**Reference:** A/18/8/PL for Application for Variation of Condition 2 imposed under A/173/16/PL to read "the development to be carried out in accordance with the following approved plans ADC962/04 REVA, ADC962/13 & ADC962/14 relating to revised position of rooflights on east, north & south elevations. This application affects the Character & Appearance of the Angmering Conservation Area at Land Rear of 1 To 6 The Cottrells Angmering

**Location: Land Rear of 1 to 6 The Cottrells, Angmering**

Ref: Drawing ADC962/14: Elevations and Sections:

A		Layout amended		10.11.17	
Rev		Description		Date	
Job Reference		Client			
New House The Cottrells Angmering, BN16 4AF		AM Homes Ltd			
Drawing Title		Drawing No		Rev	
Ground Floor Plan		ADC962/04		A	
Date	Scale	Dwg Size	Plot Style	Drawn	Checked
24.04.17	1:100	A3	ADC-red	TGS	AD

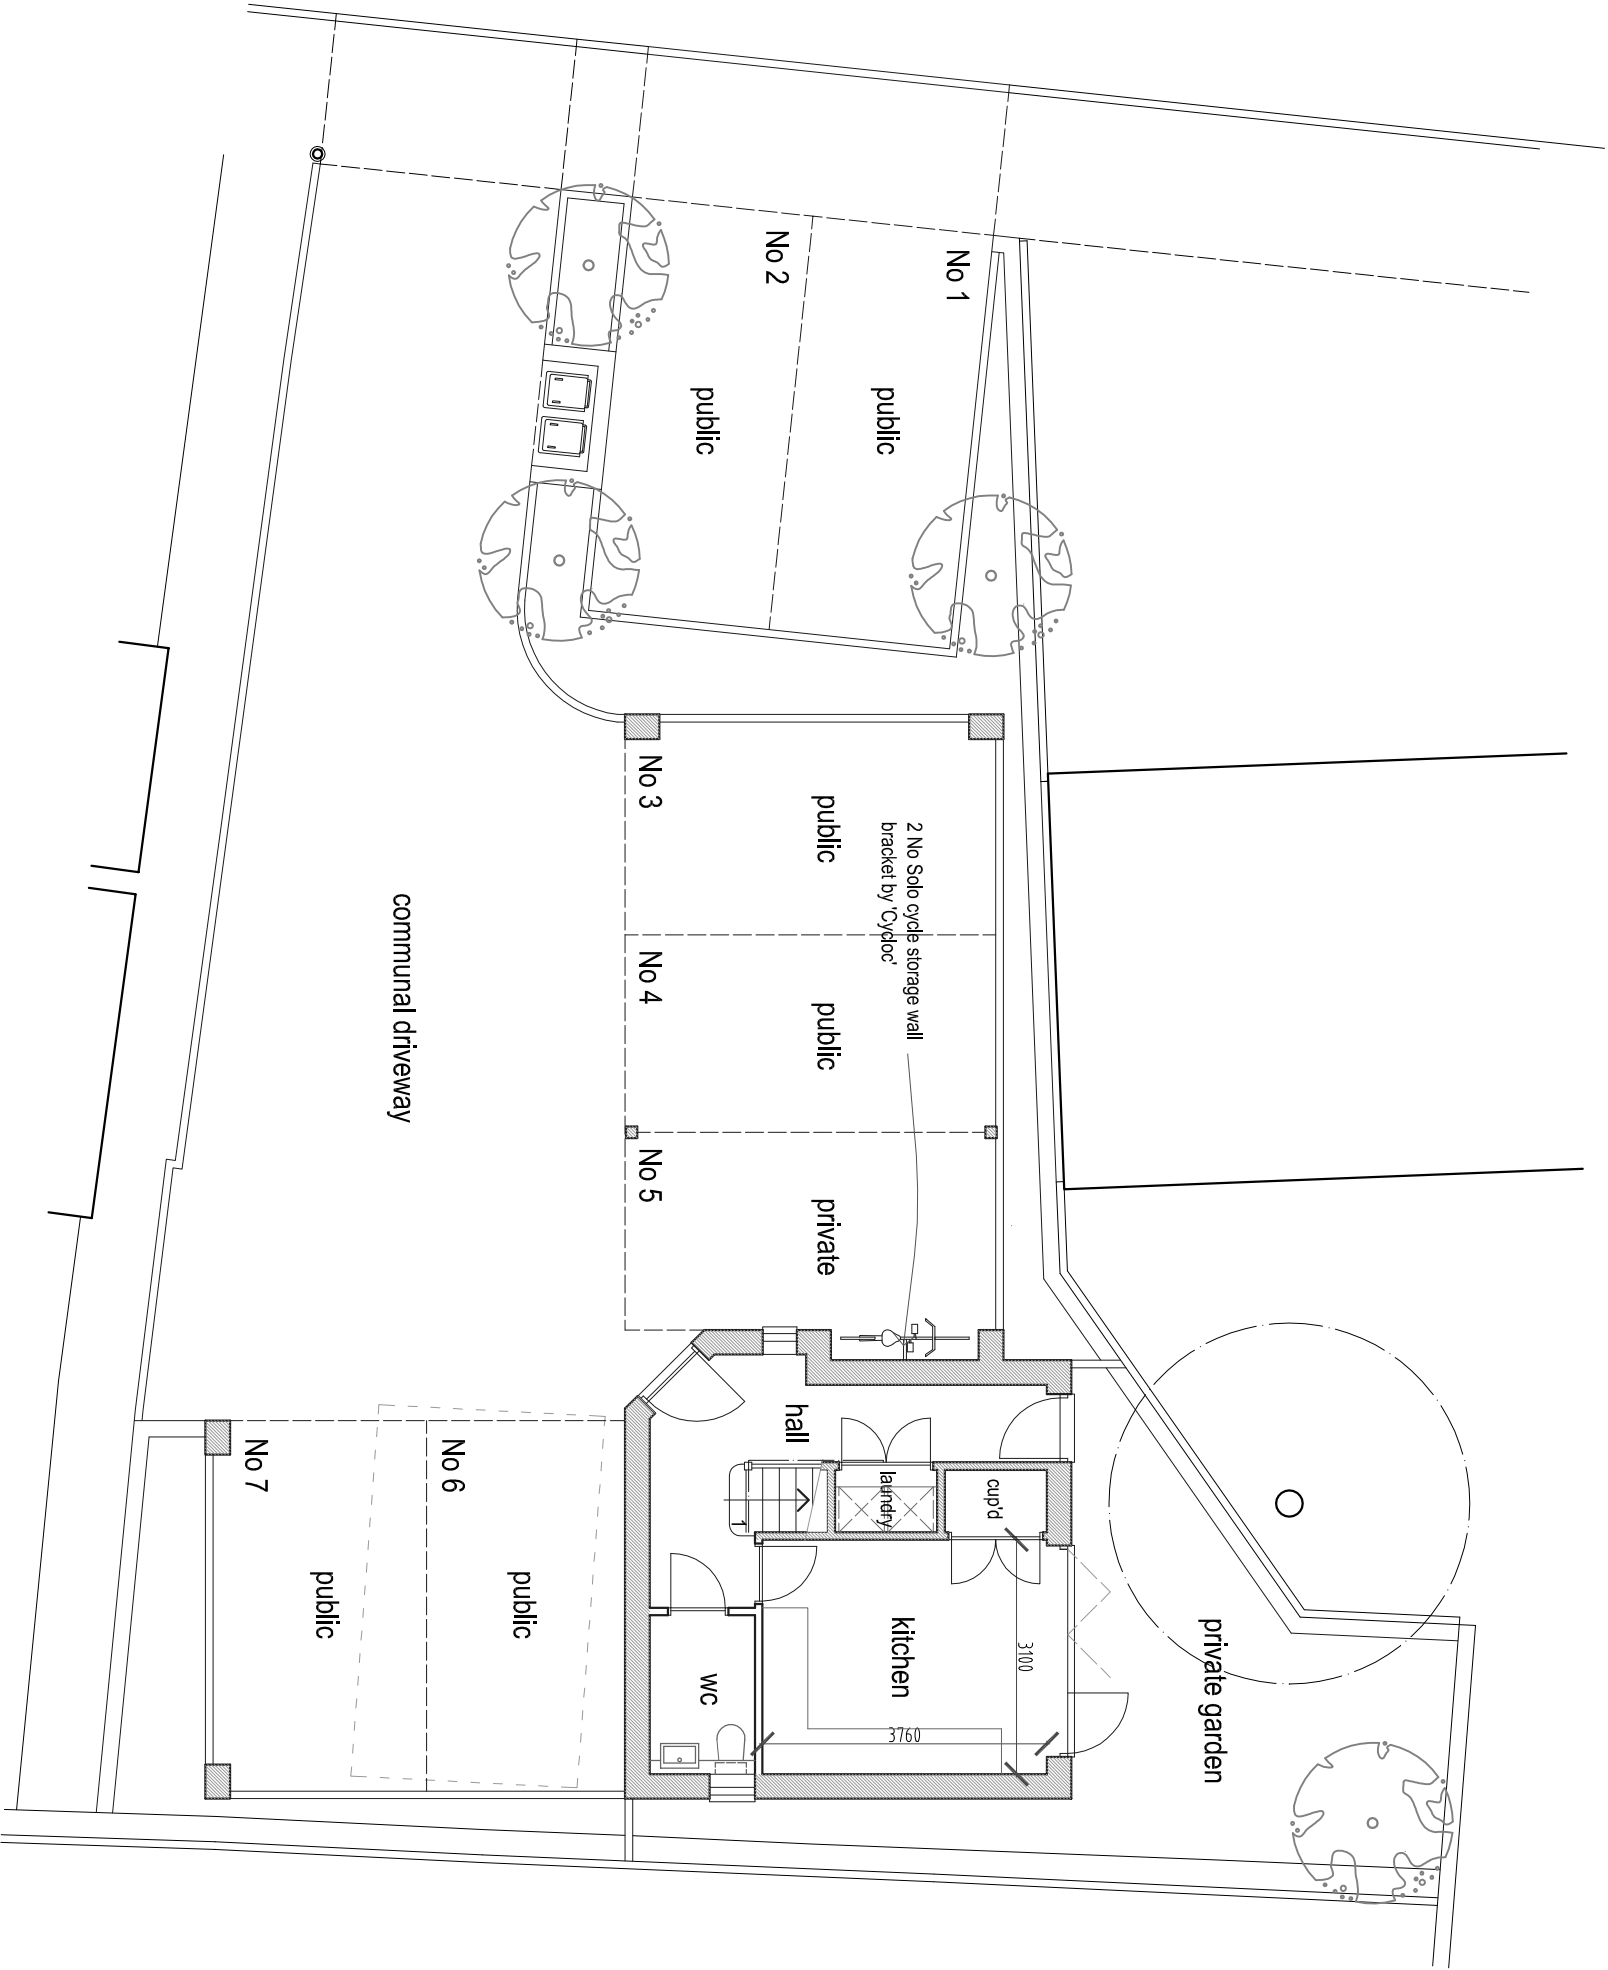
The internal changes mean that the rooms can be moved around and internal space increased. It seems that they are intending to have a third bedroom. I understand that the plumbing has already gone in even before approval and that the kitchen has been put upstairs. Planning permission for a 3 bedroom property on this site was categorically turned down. An additional bedroom would mean most likely extra cars in an area where parking is already an extremely serious issue. Yet it seems that the builders have yet again gone ahead with these changes already in direct contradiction of the current planning permission.

Rev	Description	Date
Job Reference New House The Cottrells Angmering, BN16 4AF		
Client AM Homes Ltd		
Drawing Title First Floor Plan & Roof Plan		Drawing No ADC962/13
Date 16.01.18	Scale 1:100	Dwg Size A3
		Plot Style ADgrey.spl
		Drawn AD
		Checked AD

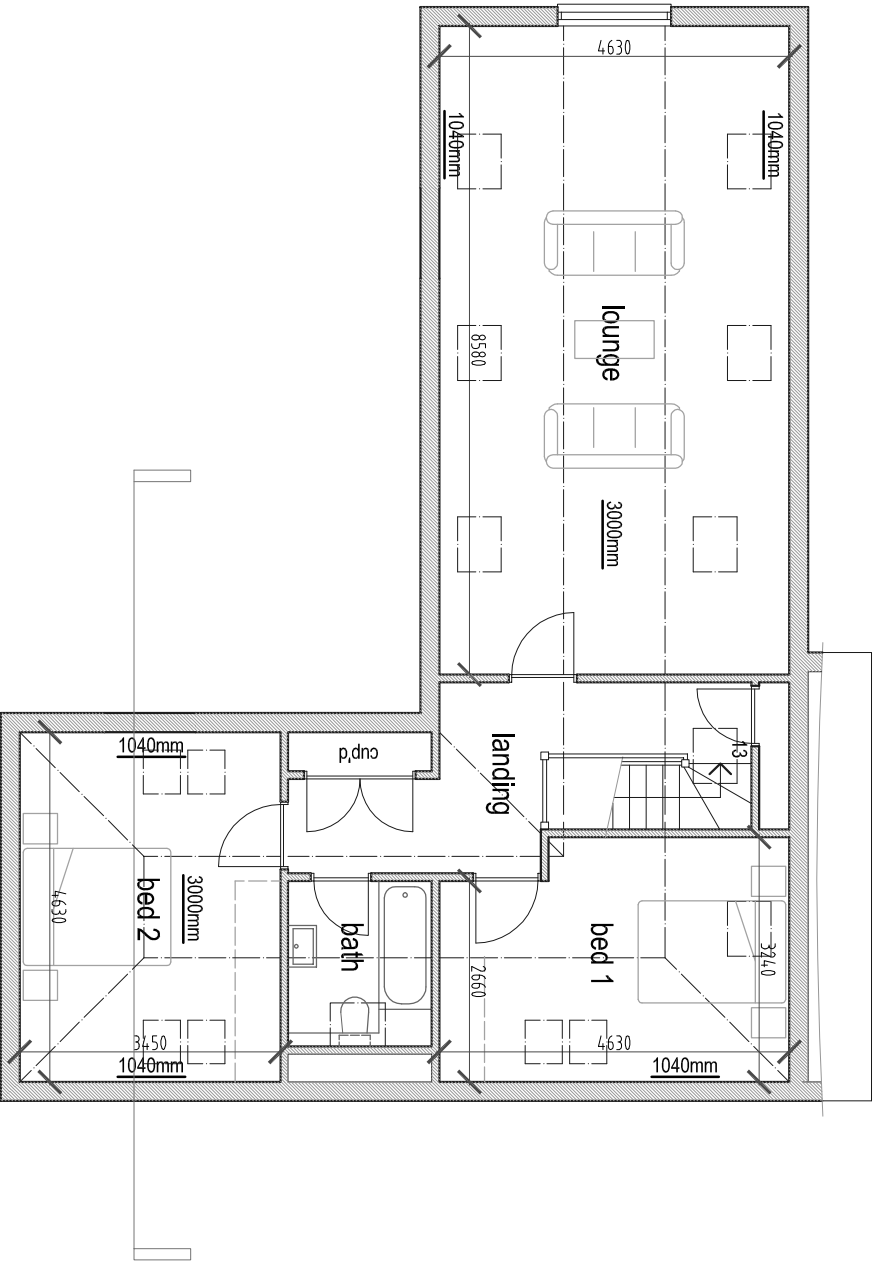
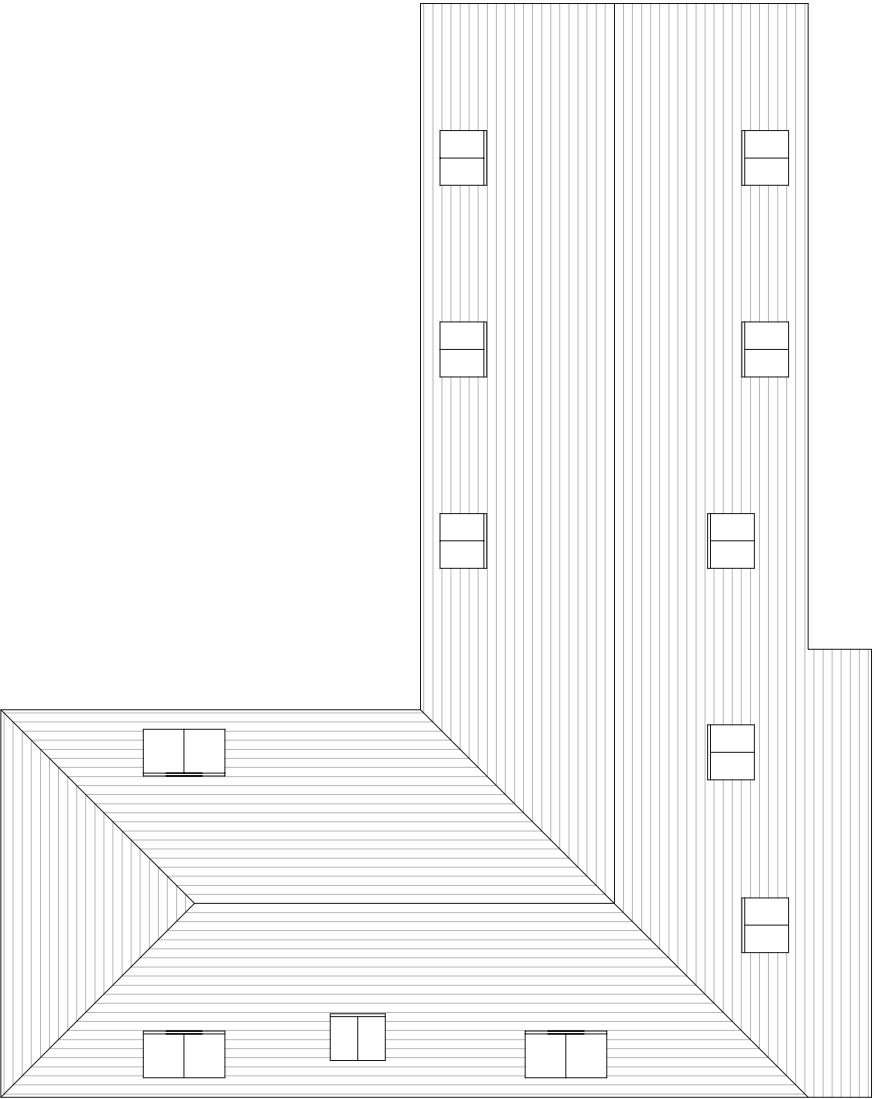
The elevations on this drawing are conflicting - they differ in their representations of the construction of the roof on the South Elevation. The West and East elevations on this drawing show a hip end on the roof that forms the south elevation as does ADC 962/13. The south elevation drawing however shows a barn end. The building that has currently been constructed shows a barn end so it can only be presumed that this is the developer's plan.

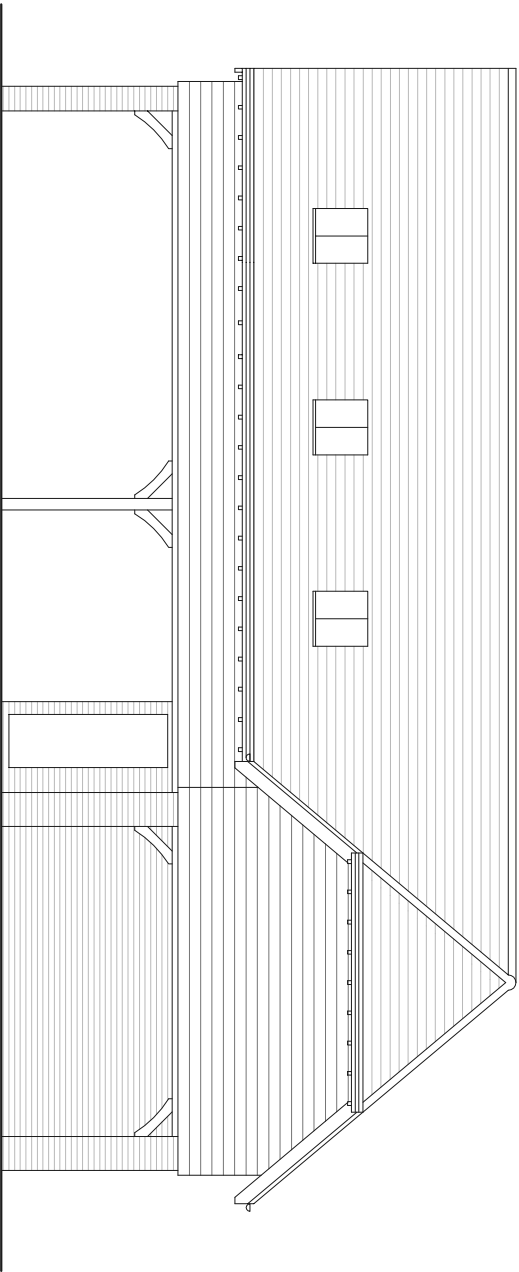
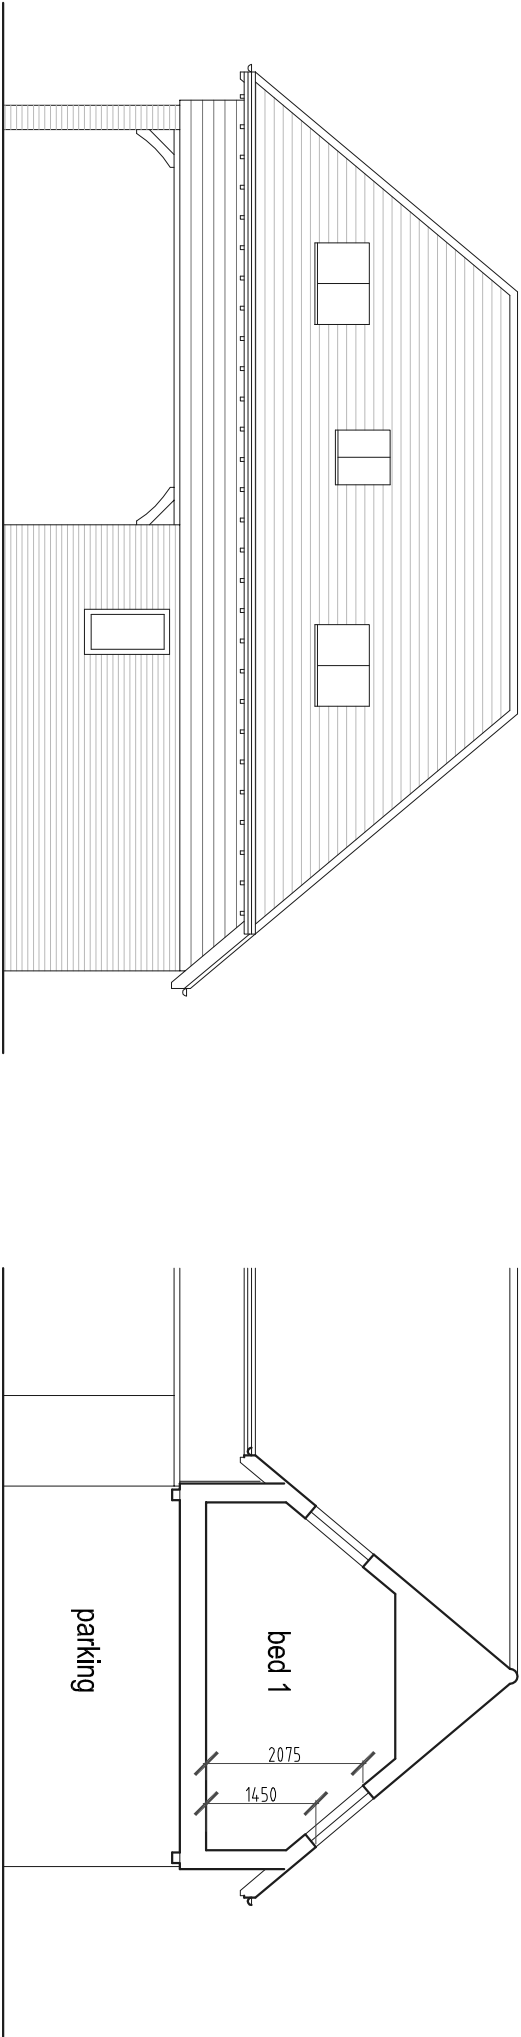
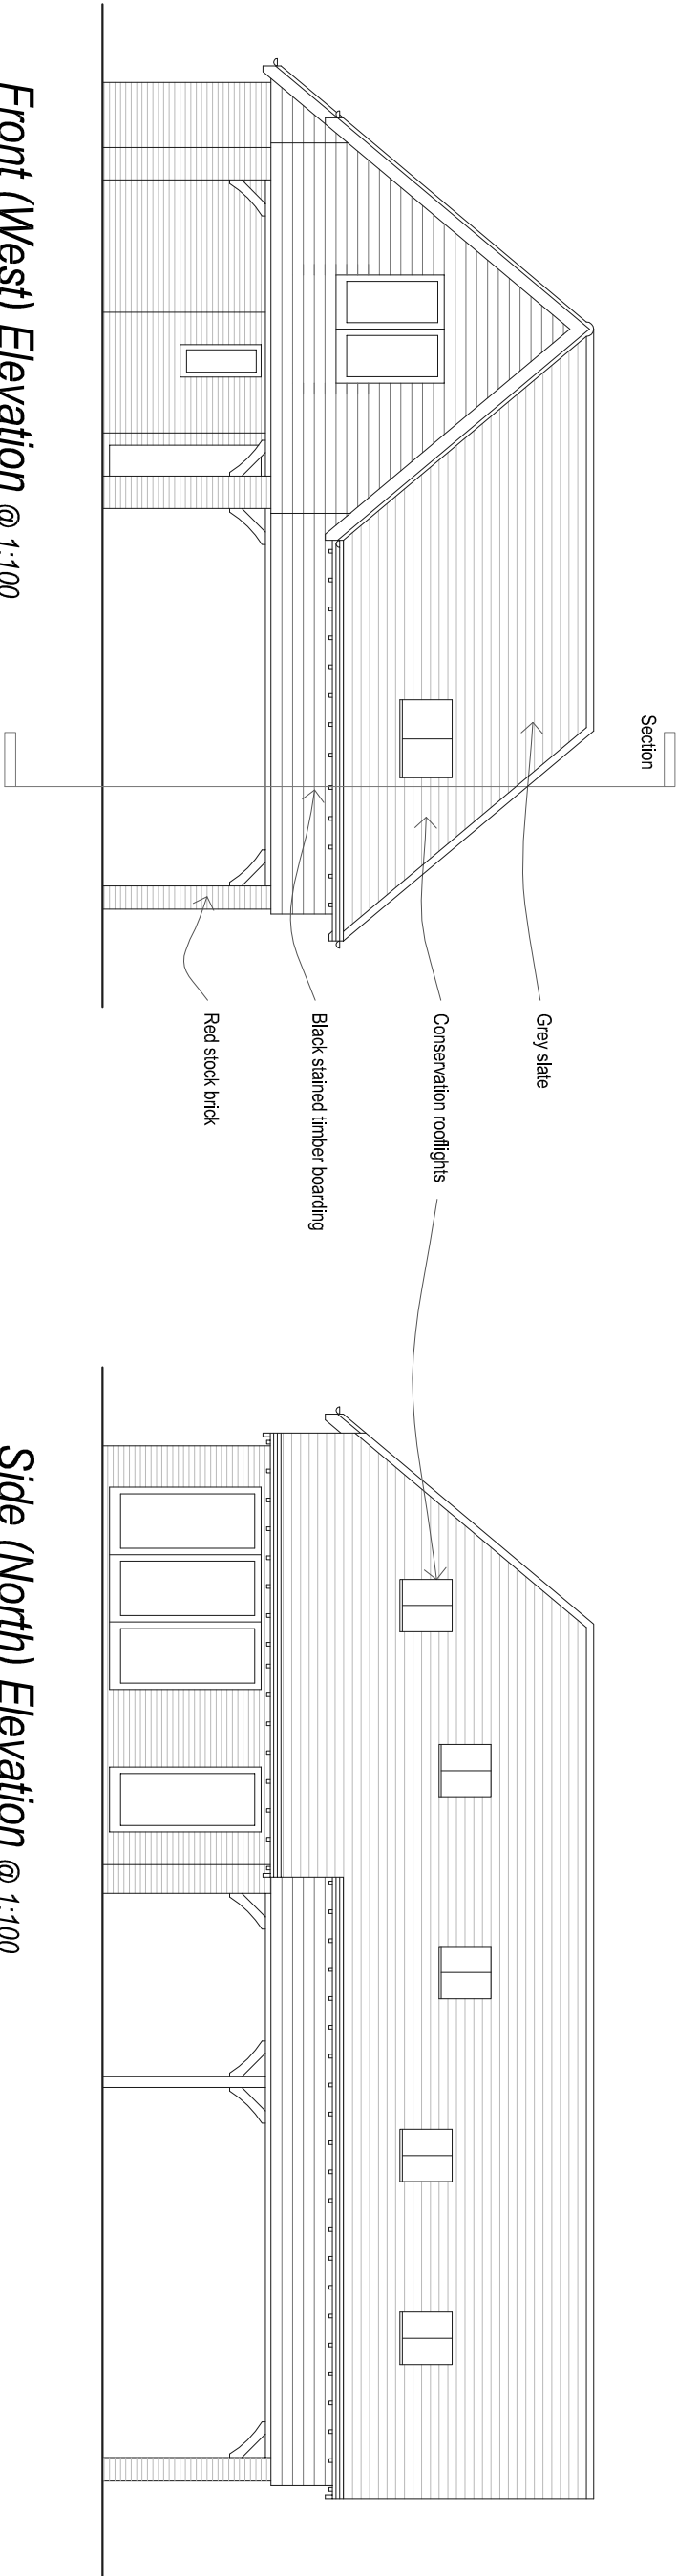
The application wording appears very misleading; the wording references only the roof light locations whereas the drawings and current construction also show a major deviation from the approved plans.

I cannot object strongly enough to this barn end. It is completely different to the original plans and it is obviously the intention to surreptitiously gain internal space. This building can only be described as an eyesore and makes our and our neighbours gardens almost blocked in and is so overbearing that it makes the gardens unpleasant places to be. Nobody could possibly fail to see the horrendous impact that this has on the local environment. It is completely and utterly out of character with the rest of the area. Several properties are also severely affected by loss of light.

**I request that the roof is taken back to the hip end the original approved application (A/173/16/PL) and the positioning of the building to be considered so that there is no overhang over the site's boundaries and all future maintenance can be achieved from within the site itself. .**
